**ADC Planning Consultation
Response from the Historic Buildings Adviser**

Application Number	Y/54/13/L
Address	Bonhams Farmhouse, Yapton
Description	Application for Listed Building Consent for removal of 9 No existing rotten sash windows and replacement with 9 No new purpose made box sash windows.
Case Officer	Janice Chapman
Site Visit

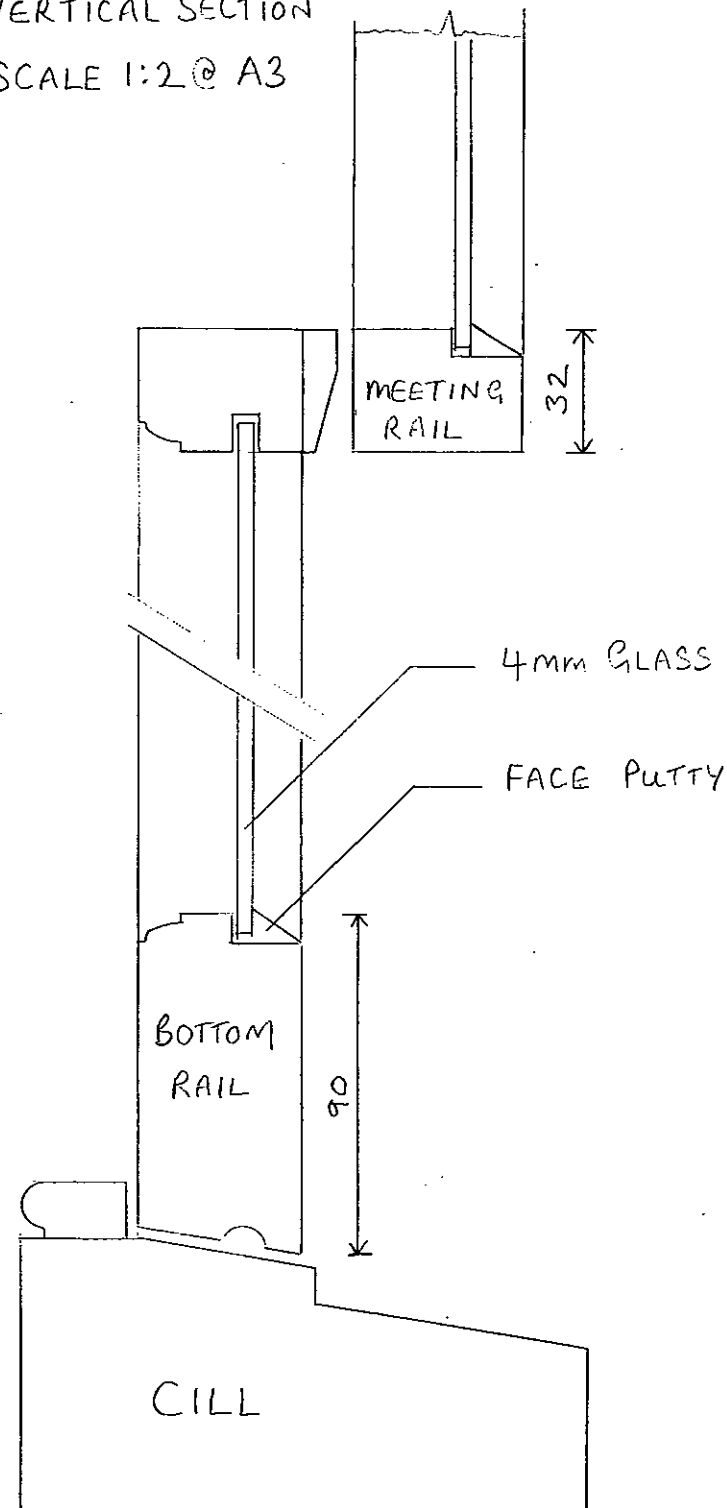
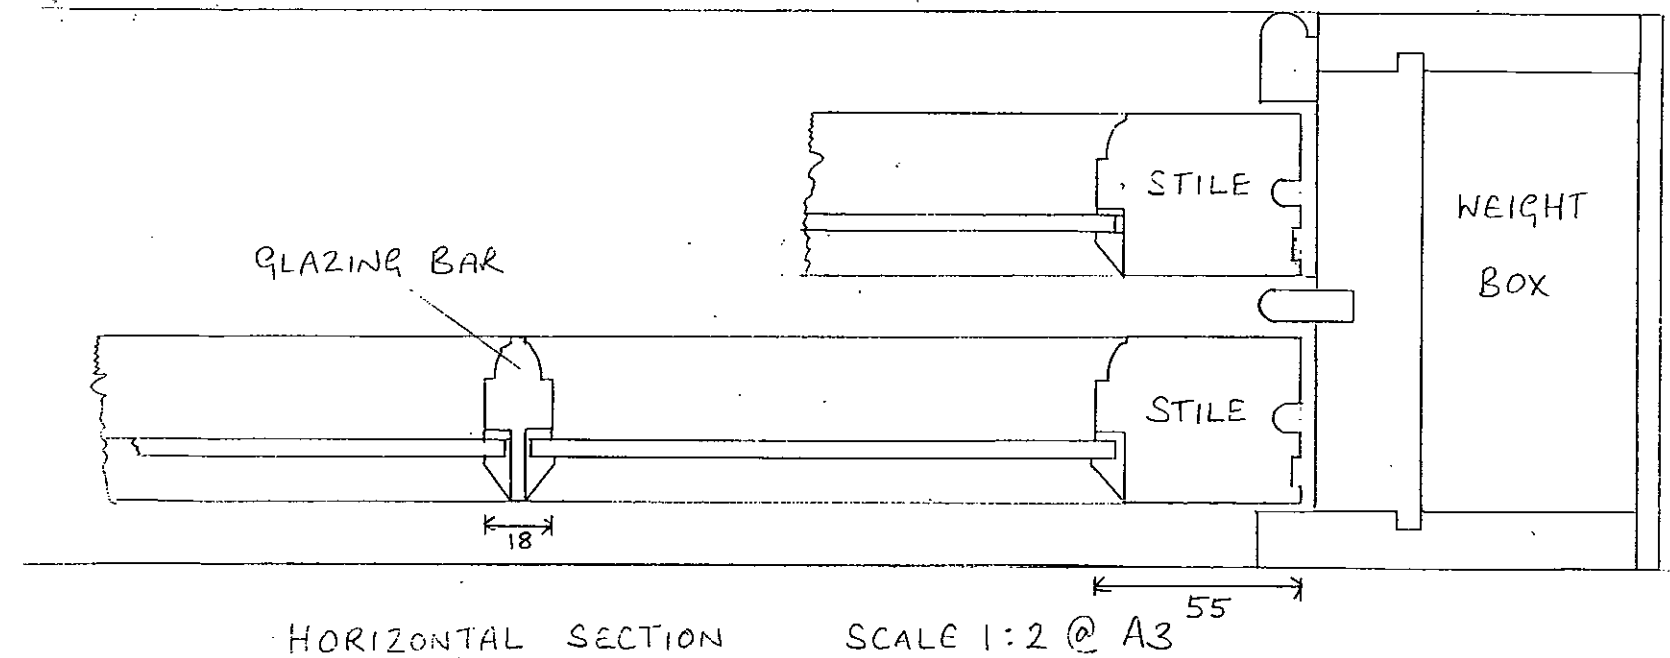
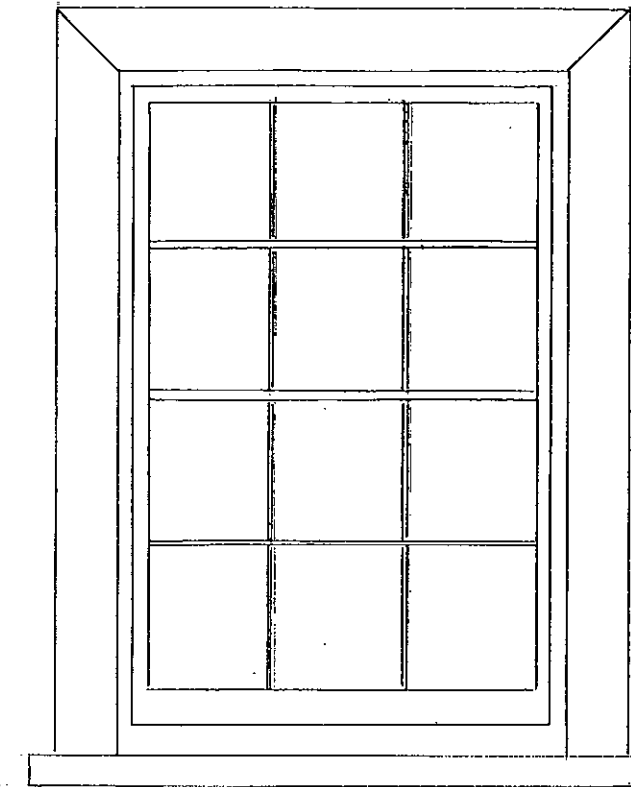
Whilst there is no objection in this instance to the principle of changing the windows in the main house due to poor alteration and condition, the windows in the addition (W6, W7, W8, W9) should be retained, or at the very least copied like-for-like. They should not be the same multi-paned design as the main house. This confuses the phases of development as well as distracts from the distinctive character of the main house.

If replacement is considered acceptable, further details should be required regarding the like-for-like replacement of windows W6, W7, W8 and W9. The glazing should also be re-used if it is crown glass and not be simply replaced with modern plate glass. Para 149 of English Heritage guidance states:
